From: Fraser McDonald  
To: Tony Merrilees; Ruth Bennett; Ania Dorocinska  
Cc: Shaheeh Muehbi; Joanna Bakopanos; Mark Wilson  
Subject: FW: MC-17-00001 SSD 8606 MOD 2 - Marsden Park Warehousing Estate - request for update on Drainage Engineering comments  
Date: Friday, 30 August 2019 11:07:09 AM  
Attachments: image010.jpg  
image011.png  
image012.png  
image013.jpg  
image014.png  
image015.jpg  
image002.png  
image001.png  
image005.jpg  
CO12829-14-SSDA44-B.pdf  
CO12829-14-SSDA42-B.pdf  
CO12829-14-SSDA43-B.pdf  
CO12829-14-SSDA41-B.pdf

4. Amend the Costin Roe Consulting drainage plan series Co12829.14 Issue A Drawing SSDA45 by:

SSD 8606 MOD 2 / MARSDEN PARK WAREHOUSING ESTATE

CONCEPT STORMWATER MANAGEMENT DEVICE CONFIGURATION
SCALE 1:100

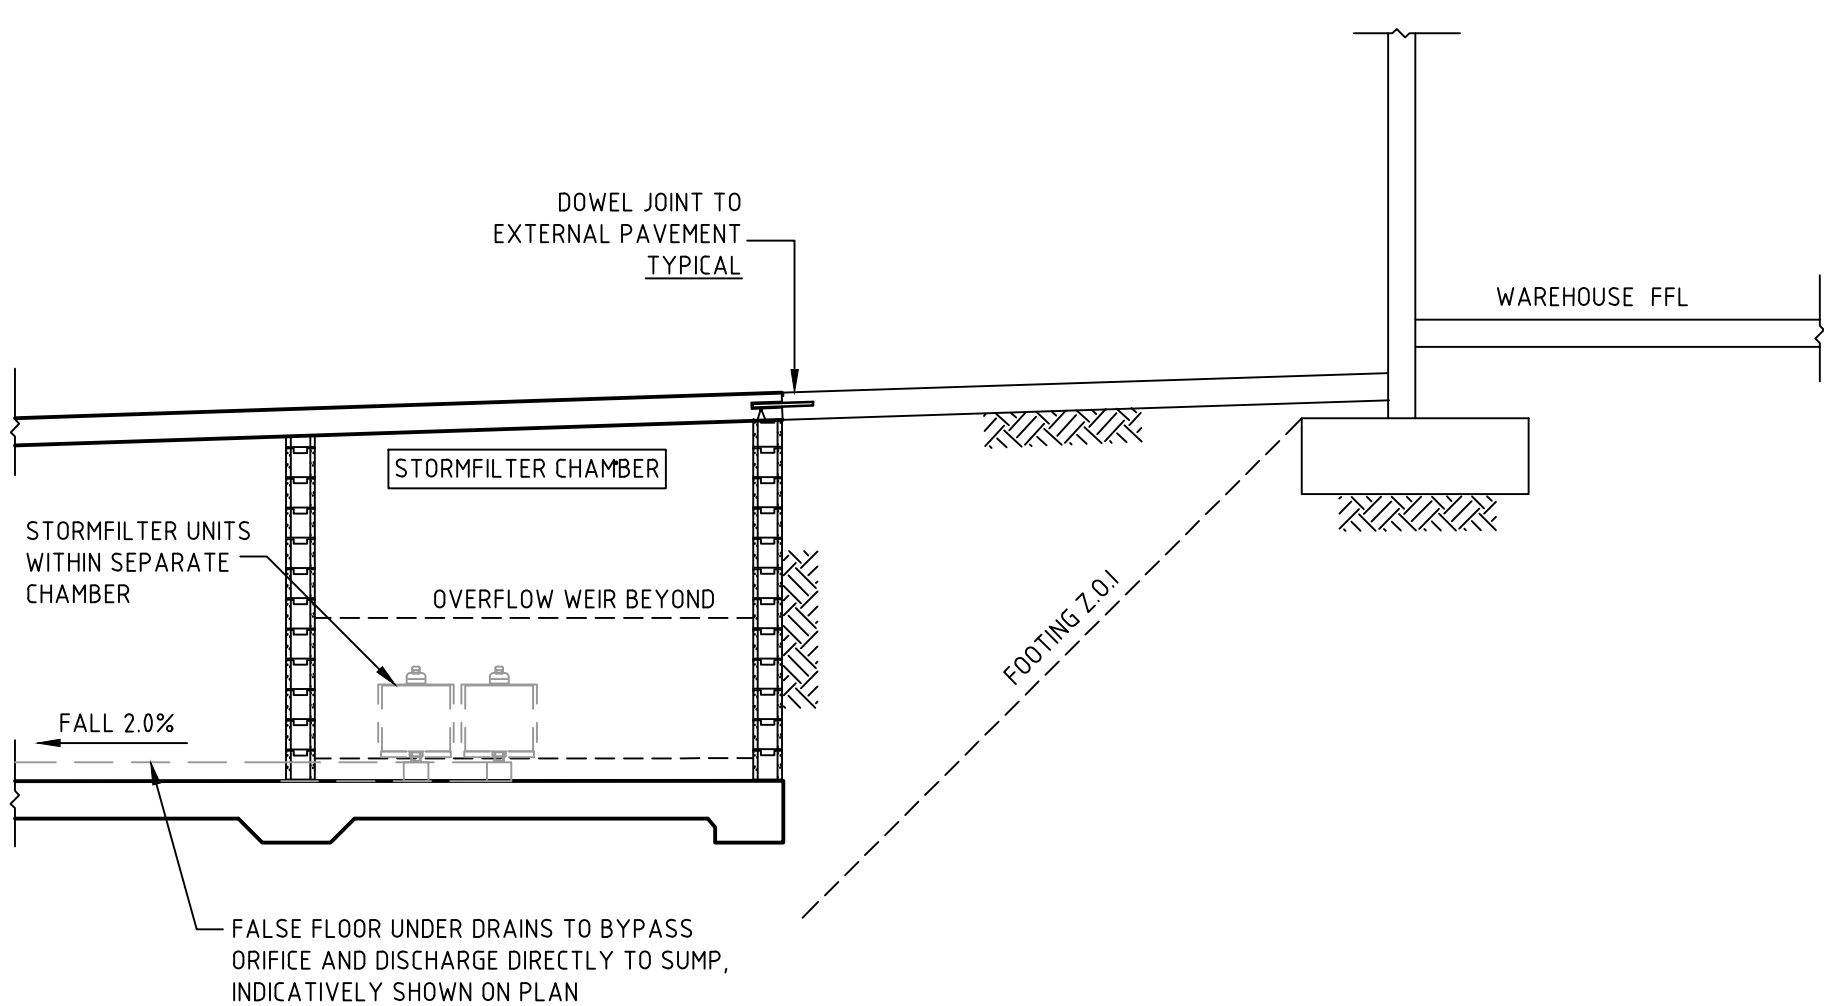
a) On the "Concept Stormwater Management Device Configuration" the red hatched area is the overflow pit only and does not contain any orifice controls.

b) On the "Concept Stormwater Management Device Configuration" provide the 1.5 year ARI pit and weir surrounding the 100 year orifice control.

c) Due to the large number of cartridges there is no 1.5 year orifice in the detention tank. The underdrain flow from the cartridges acts as the low flow control. To do this the overflow from the Stormfilter chamber that enters the main detention tank has to re-enter the Stormfilter chamber to drain. Provide a series of 150 mm pipes from each side of the detention tank with non-return flap on the inside of the central Stormfilter Chamber. Set the invert of these pipes at a minimum of 100mm above the false floor level and regrade the base of the tank at 2% to these pipe inverts. Review the tank dimensions to achieve the required storage.

e) On the "Concept Stormwater Management Device Configuration" in the Stormfilter Chambers provide two to three access points within the chamber in addition to access to the energy dissipation area.

f) On the "Concept Stormwater Management Device Configuration" delete the two references to the "Overflow Weir 920 High" as this will not be valid as the weir height relative to the tank base will vary depending upon the finished level of the tank.

g) On the "Concept Stormwater Management Device Configuration" review the grated access spacing based on the internal wall configuration. Clear access a minimum spacing is required within each section.

h) On the "Concept Stormwater Management Device Configuration" provide step irons or ladders for all grates.

Orifice size has been shown on the drawing – refer updated.

The 1.5 yr ARI pit detail has been added on drawing SSD45 in accordance with point 4c below.

A series of 150mm pipes set at a minimum of 100mm above the false floor level has been provided as shown on drawing SSDA45- refer updated.

Additional inlets have been provided as requested. Refer updated drawing.

It is noted that the weir height will vary due to the fall in the base of the tank – we have adjusted the note to reflect this and the minimum height requirement.

Minimum spacing per original SSDA is provided as specified on drawing SSDA45. The spacing varies in depth of the tank and will be finalised in detail design. It is noted that all internal walls have man-sized openings (Min 800mm wide) between all internal walls.

Step irons are noted and specified for all pits over 1200mm as required of Australian Standards. This includes OSD tank.

TYPICAL FILTRATION CHAMBER DETAIL
SCALE 1:50

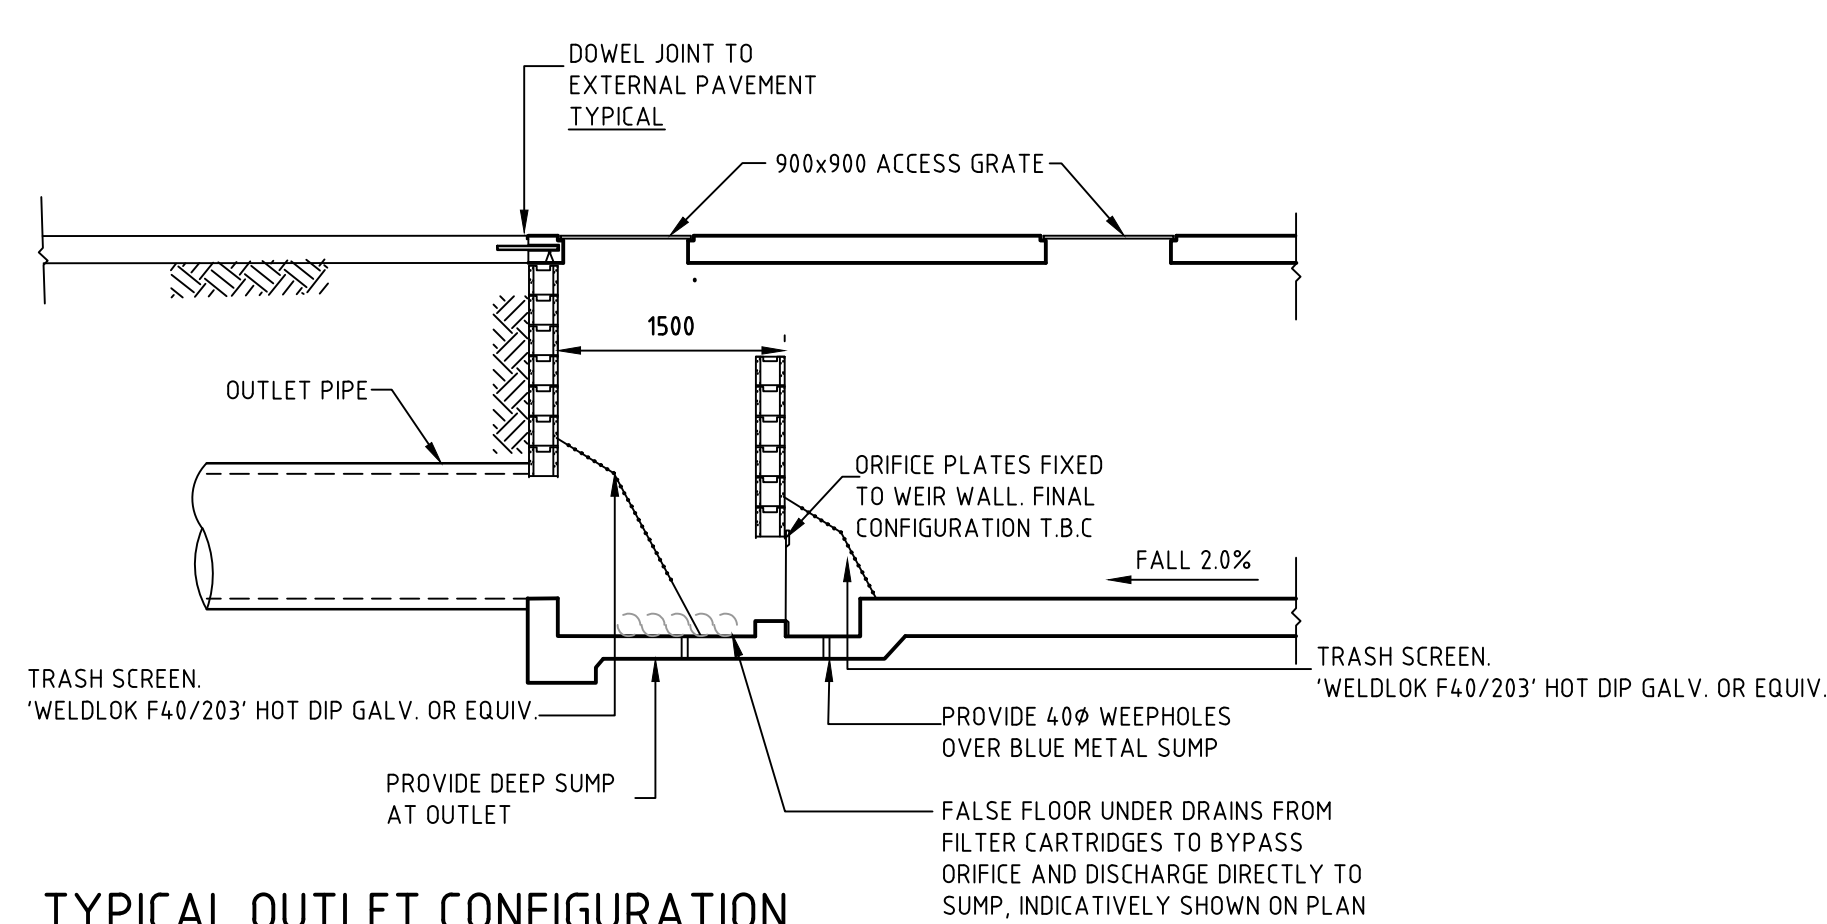
i) On the "Typical Filtration Chamber Detail" delete the reference to "920" and on the inside of the weir show a "150 False Floor" and a "770 Weir above False Floor".

Noted per item f) response.

TYPICAL OUTLET CONFIGURATION
SCALE 1:50

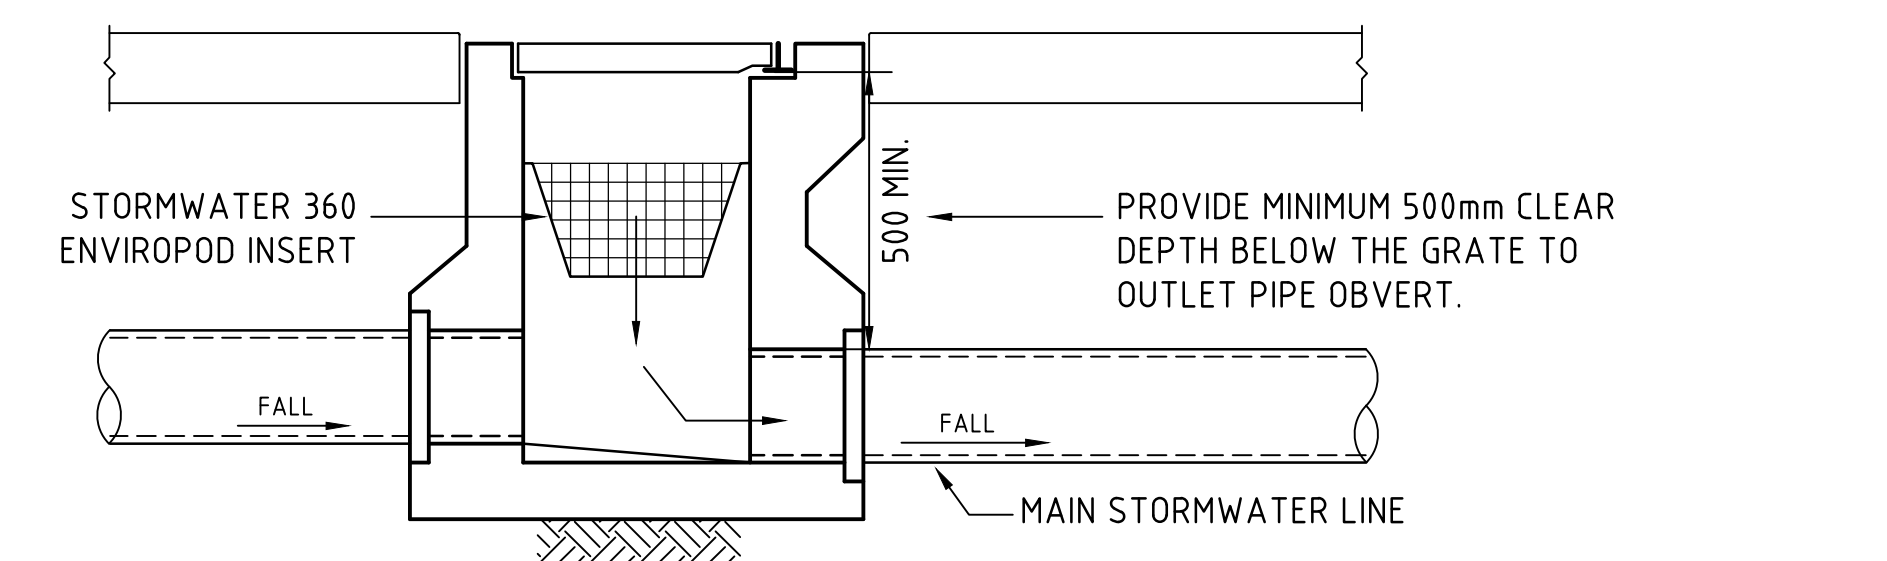
j) On the "Typical Outlet Configuration" either lower the invert of the outlet pipe to be at or below the lower of the underdrain pipe inverts or the 100 year orifice / pipe invert.

l) On the "Typical Outlet Configuration" delete the Weldlok screen from the Overflow Chamber.

m) On the "Typical Outlet Configuration" the reference and location of "1500" is unclear.

Refer updated detail to reflect the above.

Removed as requested.

This is the distance between the external perimeter wall and the weir wall.

RAINWATER TANK CONFIGURATION
(DIAGRAMMATICAL ONLY, NOT TO SCALE)
DETAIL IS TYPICAL, FIRST FLUSH DEVICE AND OVERFLOW TO BE PROVIDED. REUSE PUMP SET, RETICULATION, FLOAT SWITCHES AND TOP-UP REQUIREMENTS AS PER HYDRAULIC ENGINEERS DRAWINGS & DETAILS.

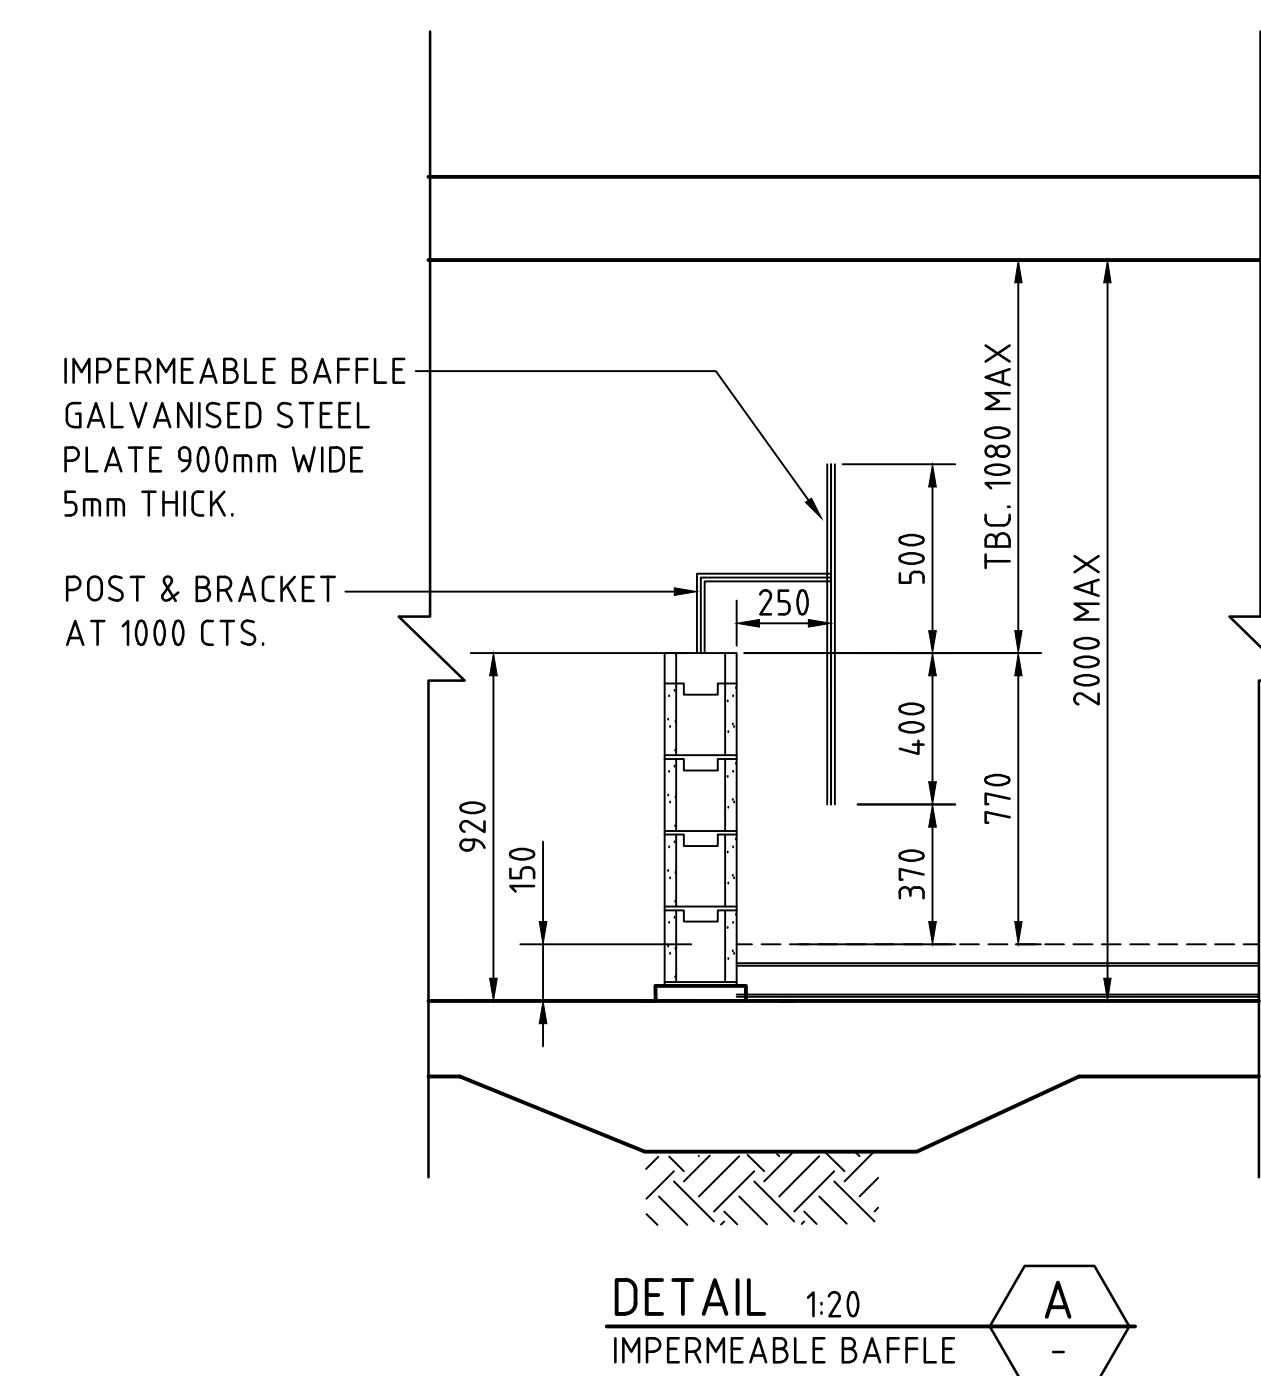
n) On the "Rainwater Tank Configuration" delete the single 180 kL tank and show how the two 120 kL tank (240 kL total) configuration will work.

Refer updated detail which confirms the two tank configuration. The arrangement is based on a balance pipe connection 300mm from the base of tanks, with primary discharge into and overflow from tank 1.

DETAIL 1:20
IMPERMEABLE BAFFLE

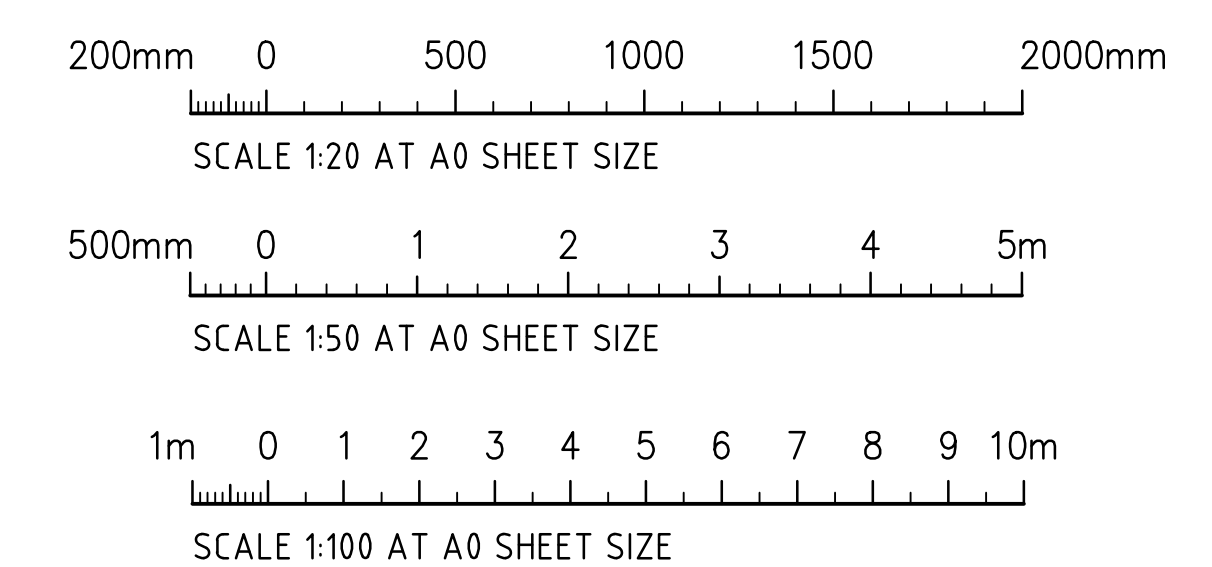
o) On "Detail A" delete the reference to "900mm WIDE" and "500". The baffle is to extend from "400" below the weir to "200 above the 100 year storage level or to the tank soffit.

Noted adjusted per request.
